**Objection to Development Application SSD- 93020230 at 40-48 Redan Street, Mosman by Richard Wise Pollitt 69B Muston Street, Mosman**

I refer to State Significant Development Application SSD – 9302 0230 which seeks consent for the demolition of existing dwellings; construction of 10 storey residential flat building comprising: 53 apartments (including 11 in-fill affordable housing apartments), two basement levels with parking for 106 cars, communal open space and associated works at 40-48 Redan Street Mosman.

40-48 Redan Street, Mosman 40-48 Redan Street Mosman NSW 2088	Section 3 EW South Sections	Rev	Date	Description	By	Chk	Scale	Code	Sheet	Rev	0 2.5 5 10m	
		B	27/2/2026	SSD Submission - Lodgment	IS	1:250 @ A3	TPRS	4002	B

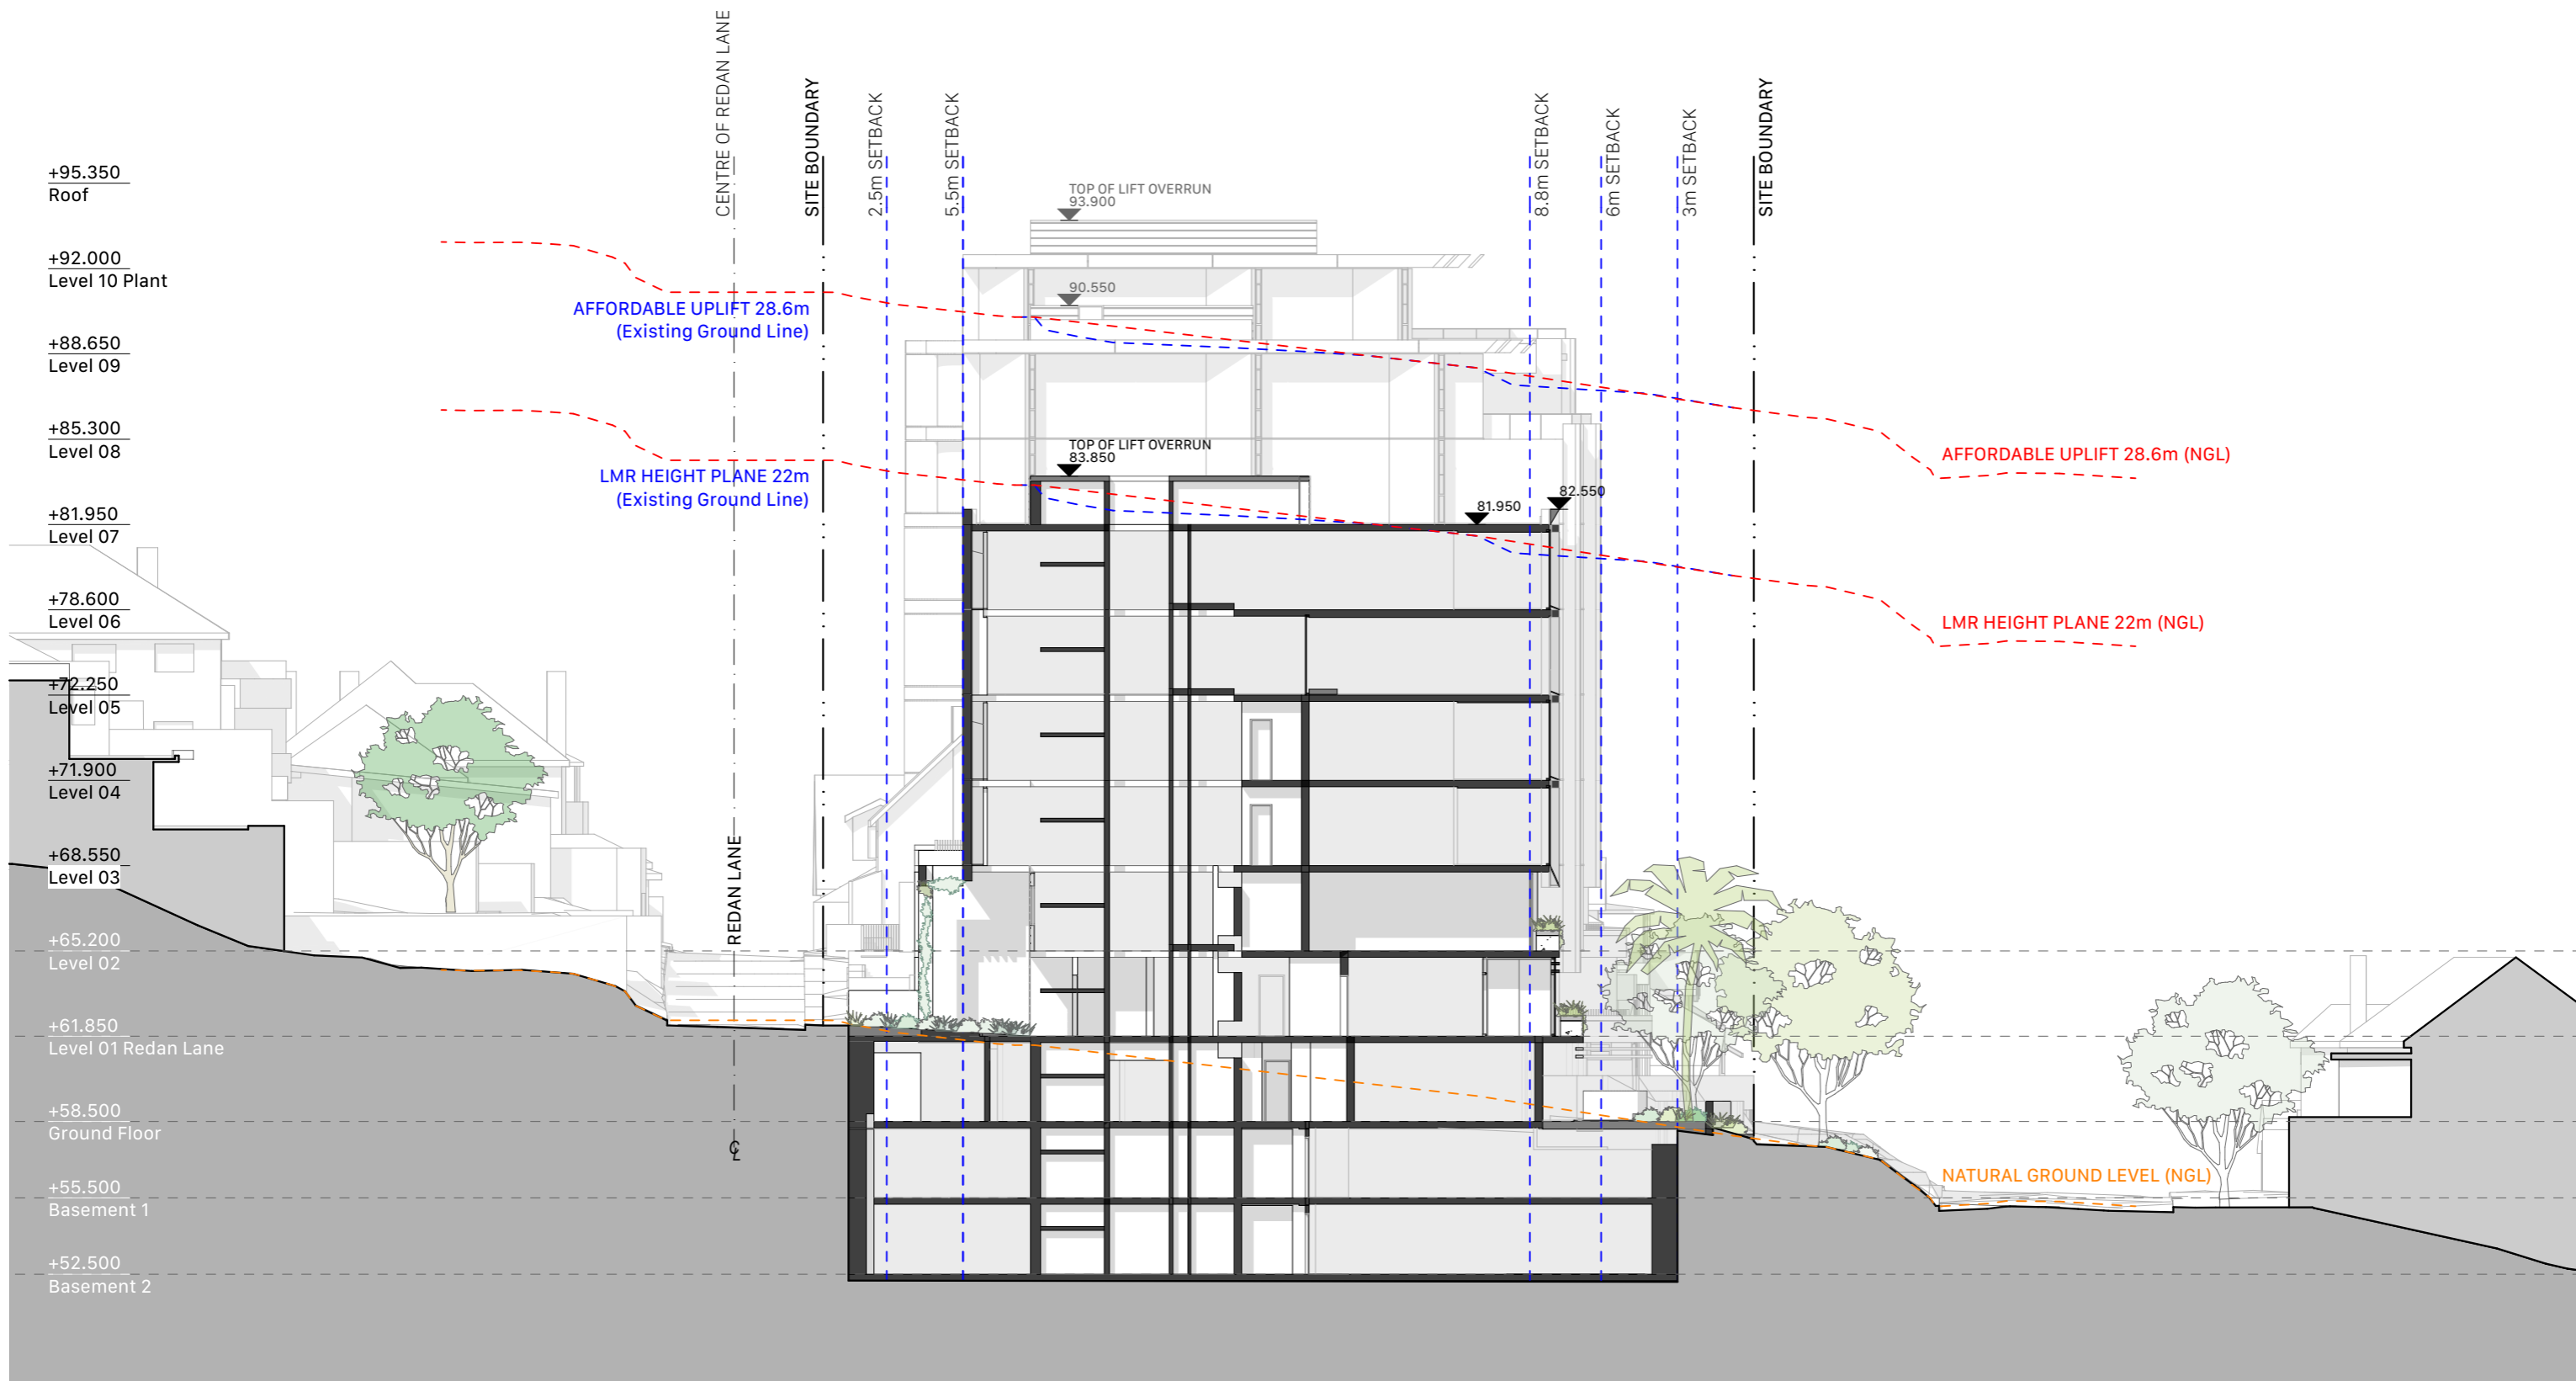
While we now look down to the sky where it meets the horizon, if the project proceeds, we would have to look up at quite an angle to see any sky at all directly in front us, and even more steeply as our gaze goes round slightly towards the North. (See Fig.5)

The SSD Submission drawings – Section 3 conveniently passes through our property, allowing a direct mark-up of the angle to the sky directly in front of us, and the higher angle over the second tower building 5° to the north.

Fig. 5 Marked up detail from SSD Submission. Section 3, showing lowest angle of sky view from 69B Muston St.
